Our Case Number: ABP-318758-23

Re: Proposed public realm improvement works known as the 'Westgate 2040 Project'
in Drogheda, County Louth

Re: Drogheda & District Chamber submission on the Westgate Vision 2040

DRAWING
Abbey Proposed Plans, Elevations Sections A-A and B-B

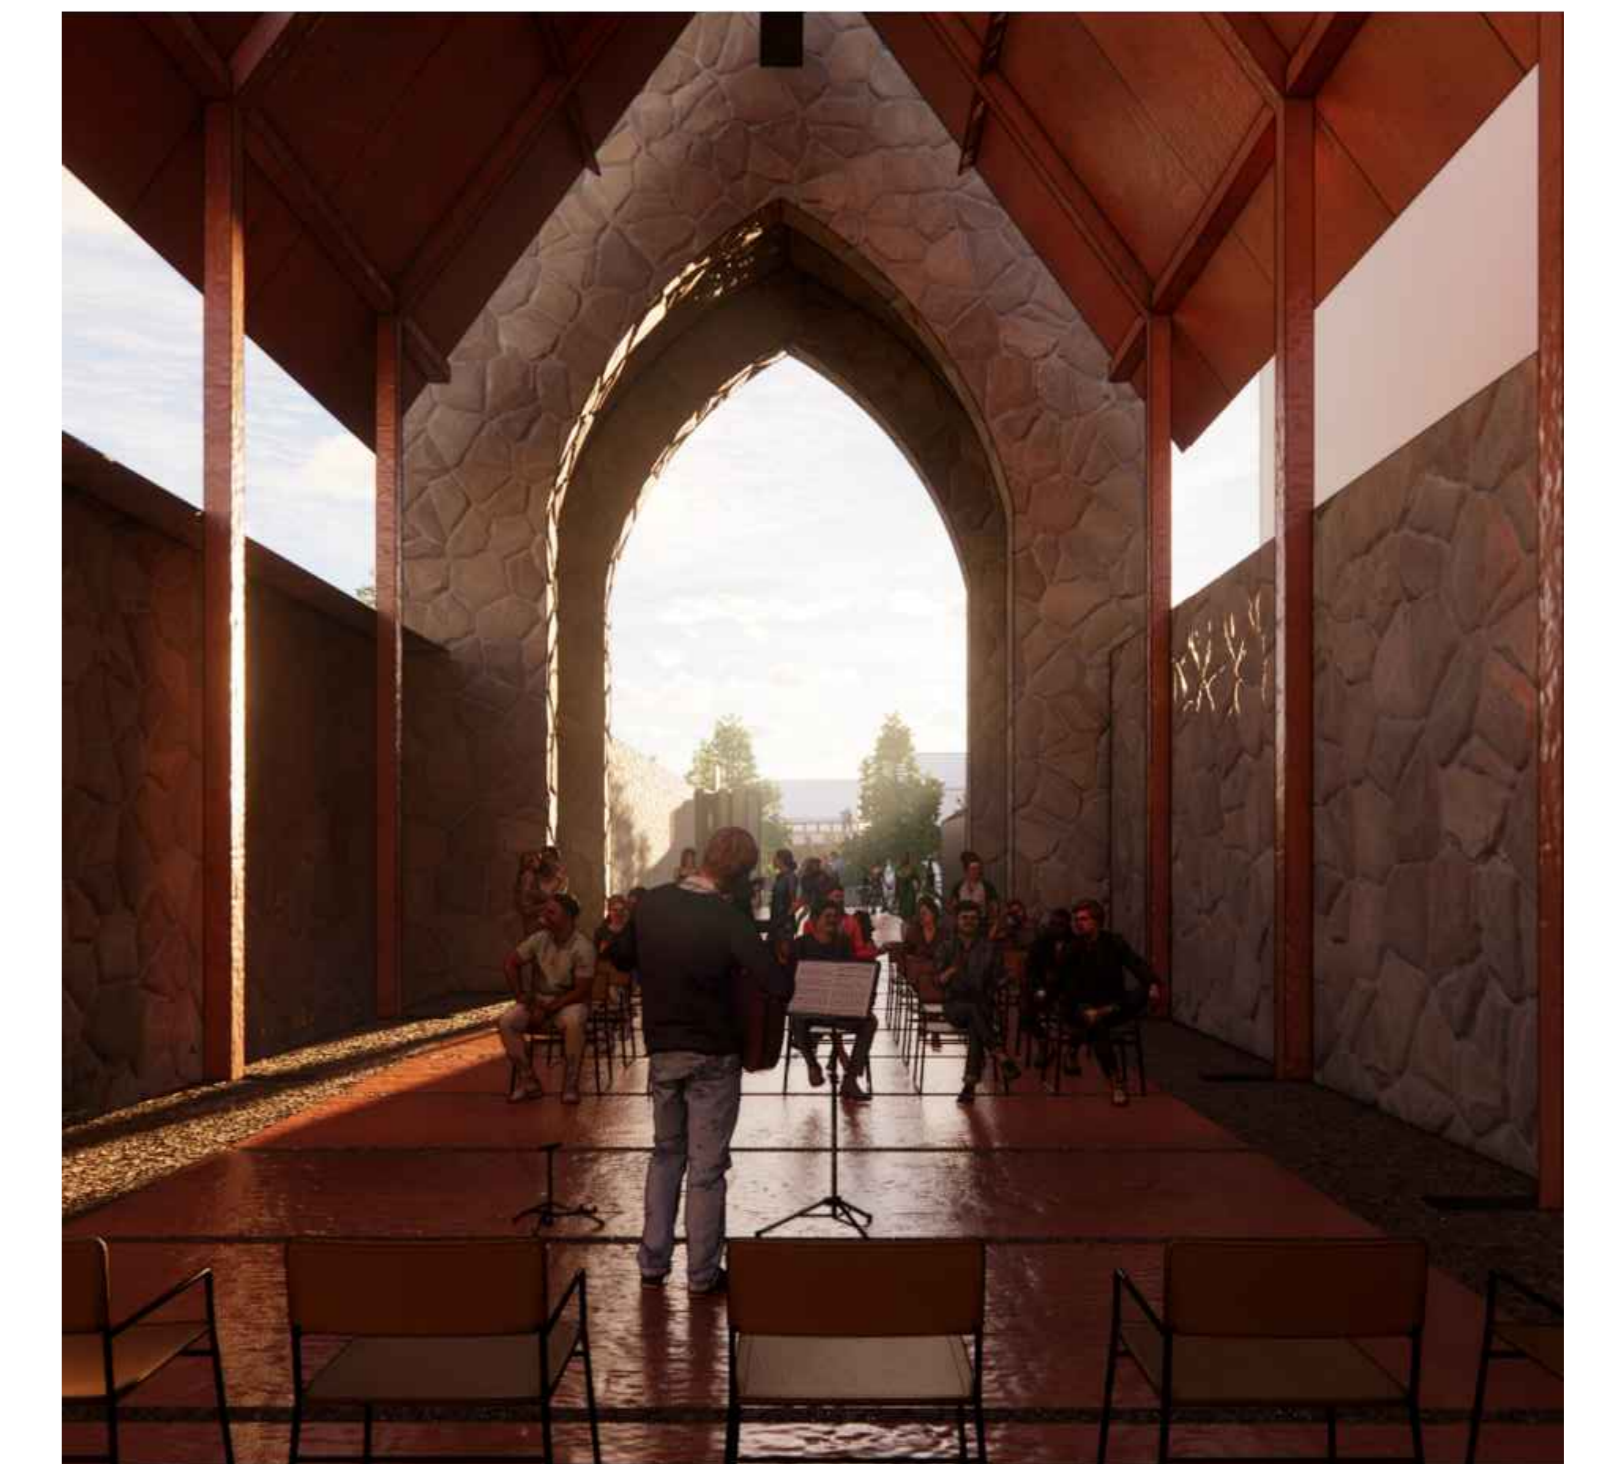
- The positioning of a corten steel canopy in the old abbey is too hard and will detract from the existing structure, a canopy at this location would be beneficial but a softer option (tension structure or similar) should be considered;

DRAWING  
Detail Drawing 1  
Corten Steel Structure at West Gate Entrance

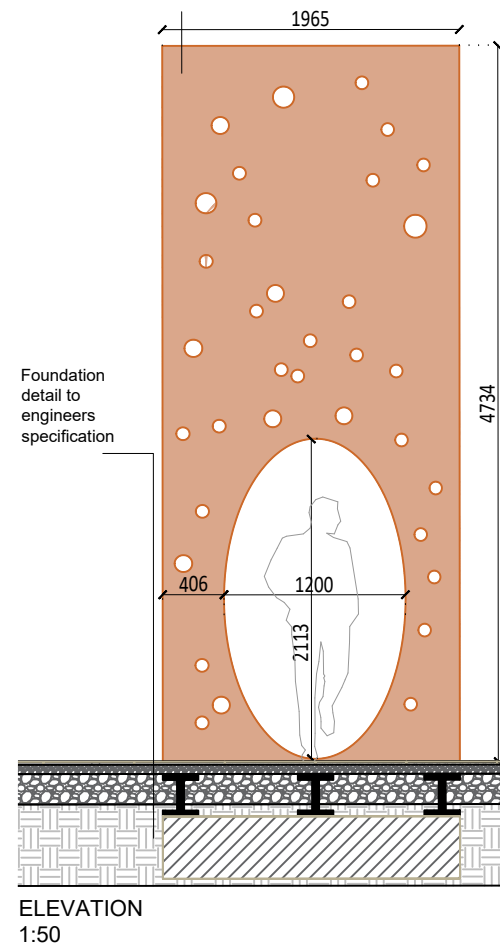
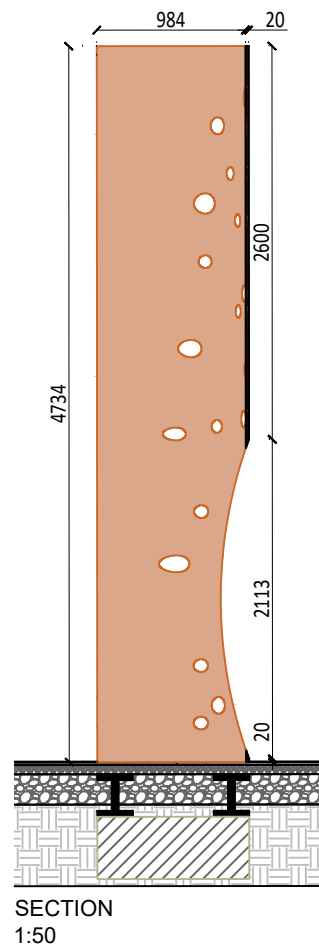
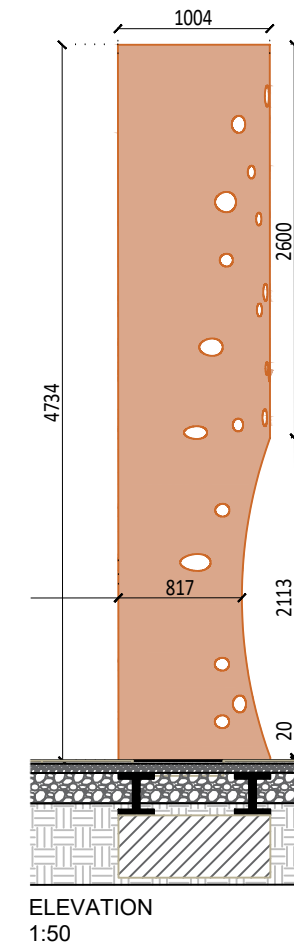
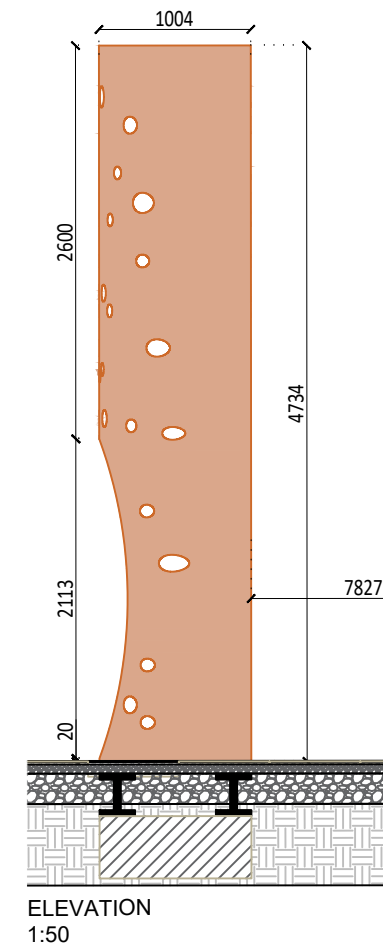
- The use of corten steel in this urban area should be re-considered. As a rusting steel material it is appropriate when located within a soft landscaped area but in hard urban landscaping it will add to the dense of dereliction and will not encourage local adoption of the project and is difficult to maintain when subjected to graffiti. A sculpture (the wanderer) located on Dominic's bridge has received considerable local negative attention for the use of rusty steel;
